Recommendation Report for Planning Permission for Works or Extension to a Dwelling

REF NO: FP/51/20/HH

LOCATION: 4 Flansham Park
Felpham
PO22 6QD

PROPOSAL: Dropped kerb and crossing.

Proposed Layout Drawing

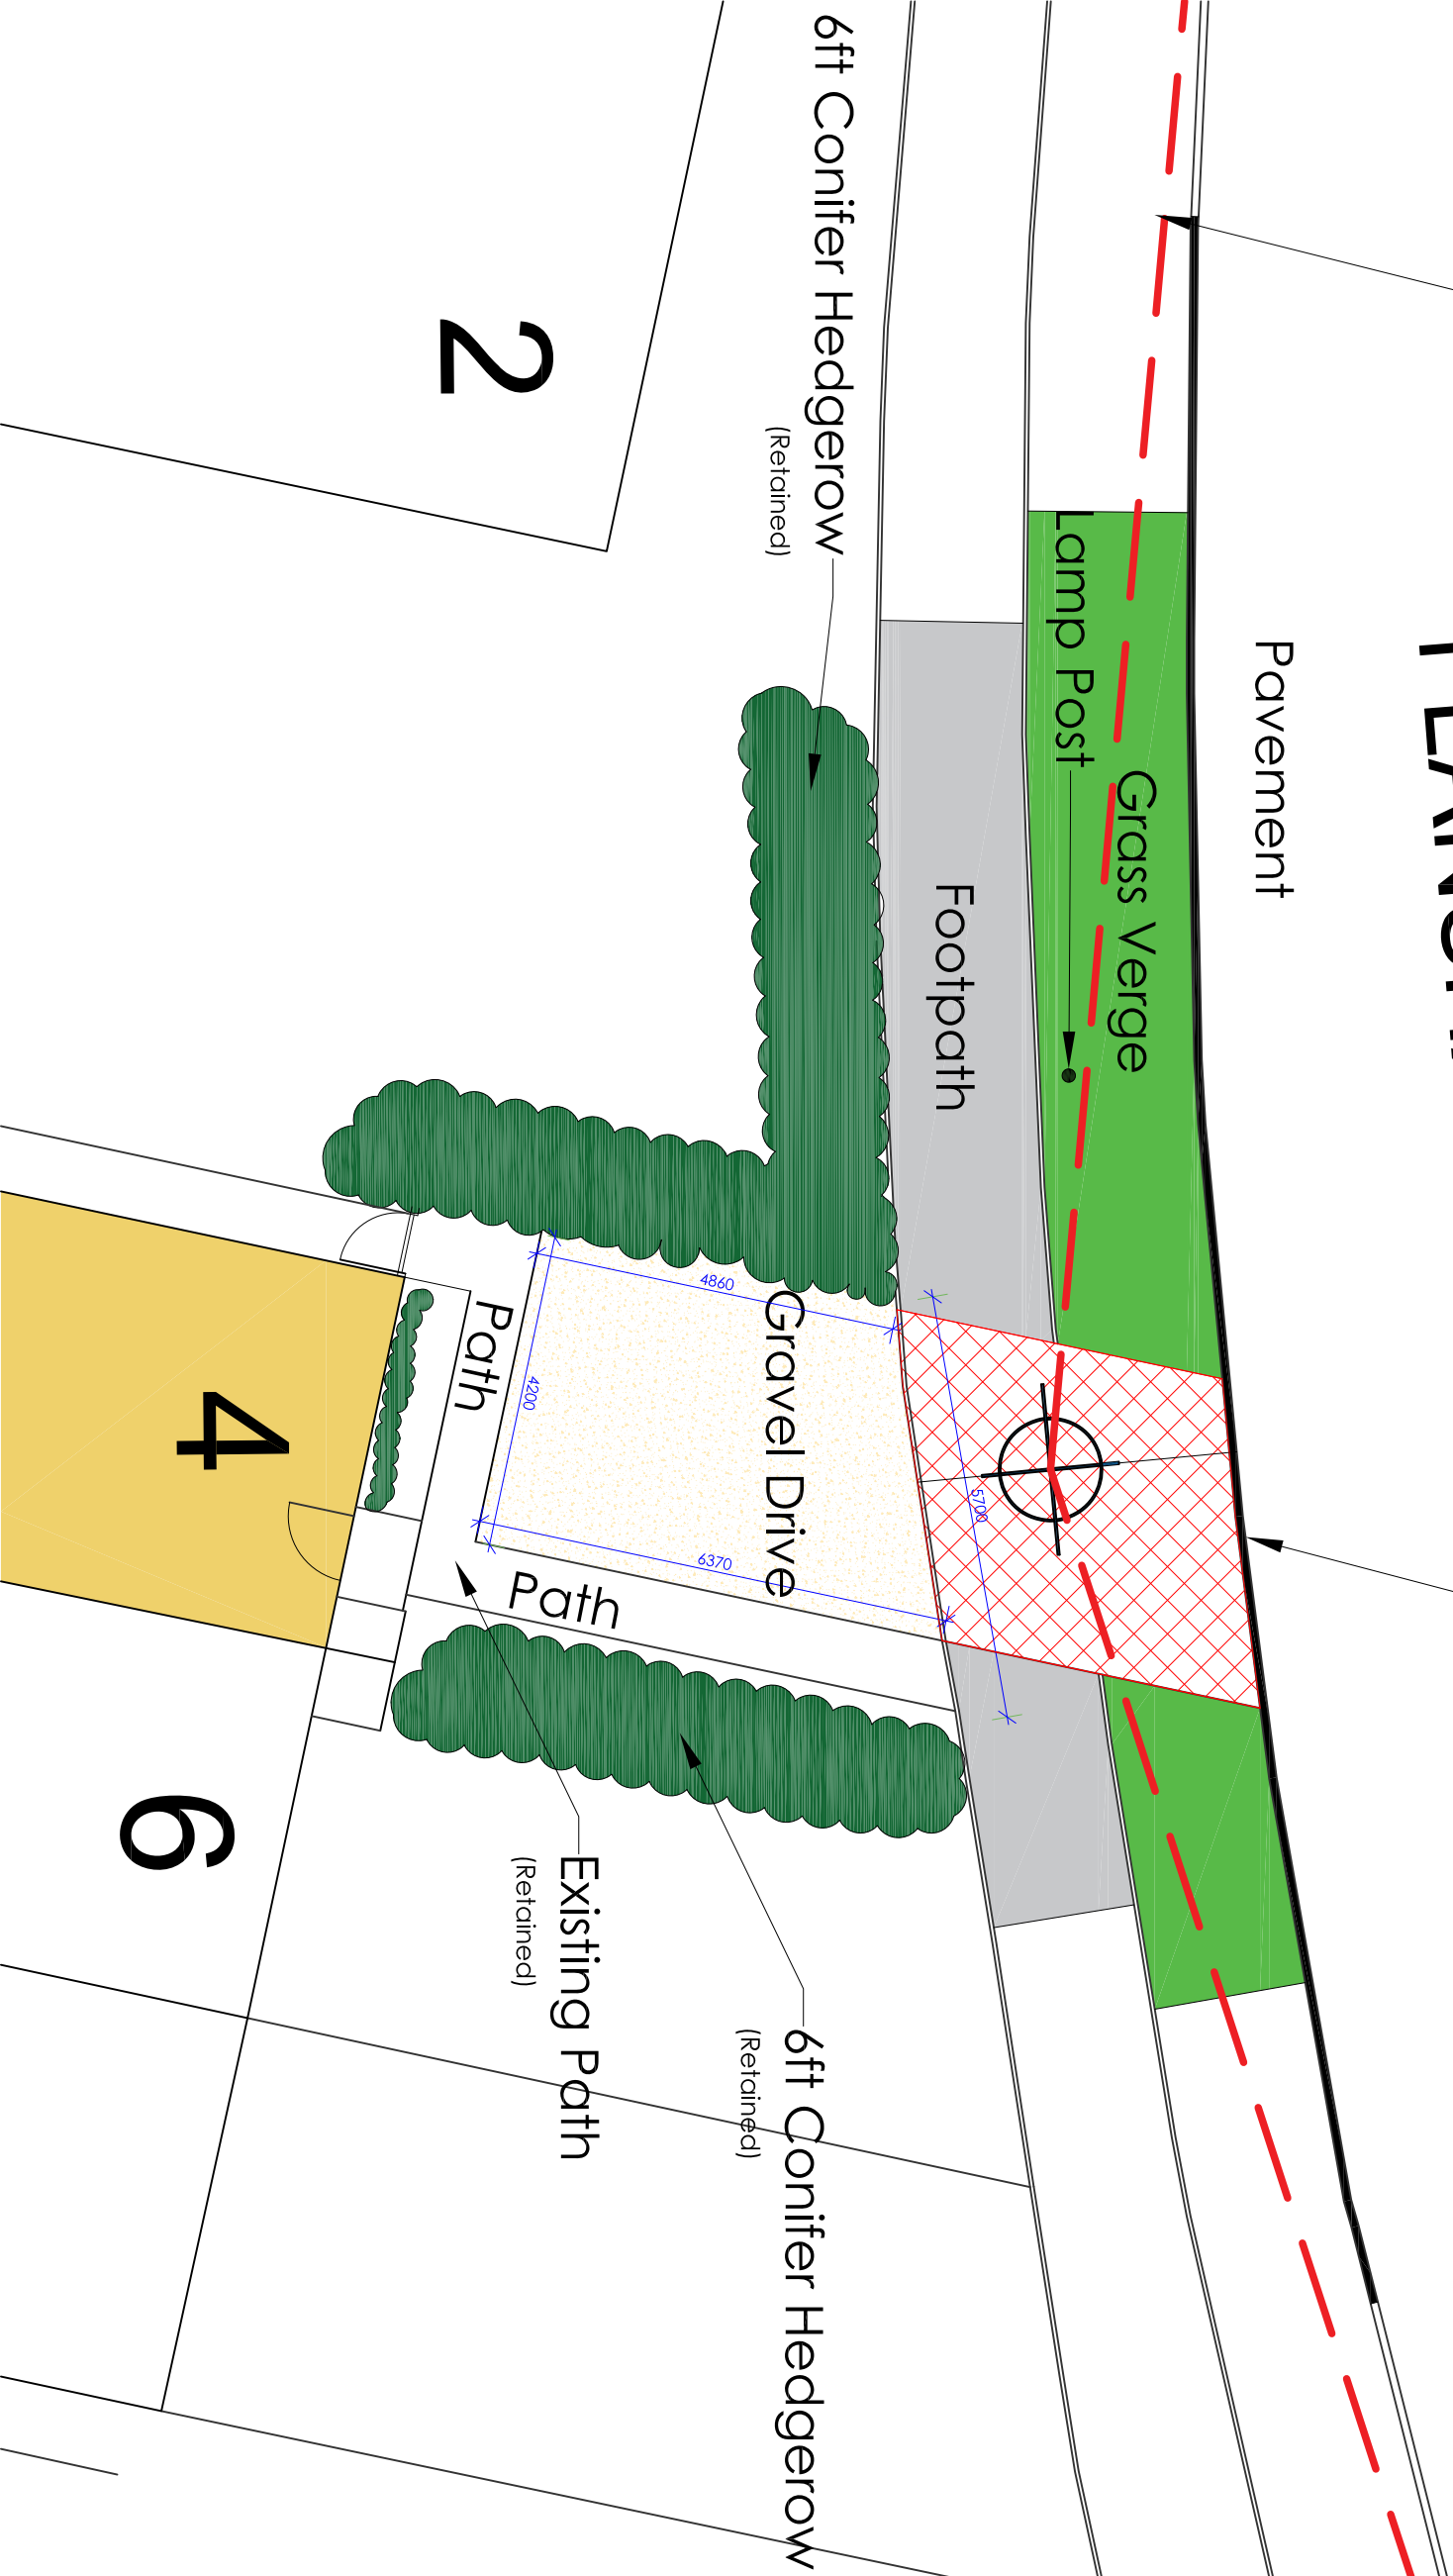
- WSCC mapping indicates that visibility splays on both sides of the proposed access is sufficient for the posted speed limit and wholly maintainable within highways land. The driveway is to be constructed from gravel. This may result in material being dispersed onto the public highway affecting the surface of the road. The applicant should provide a gravel trap or area of block paving, or other bound material, at the point of access onto Flansham Park. The LHA does not consider that this proposal would have an unacceptable impact on highway safety or result in 'severe' cumulative impacts on the operation of the highway network.

- 3 Vehicle parking shall not take place within the site frontage until such time as the vehicular access (including a bound material from the back edge of the Highway boundary to prevent gravel overspill) serving the property has been constructed in accordance with the details shown on the drawing titled 'Proposed Layout' PR/01.
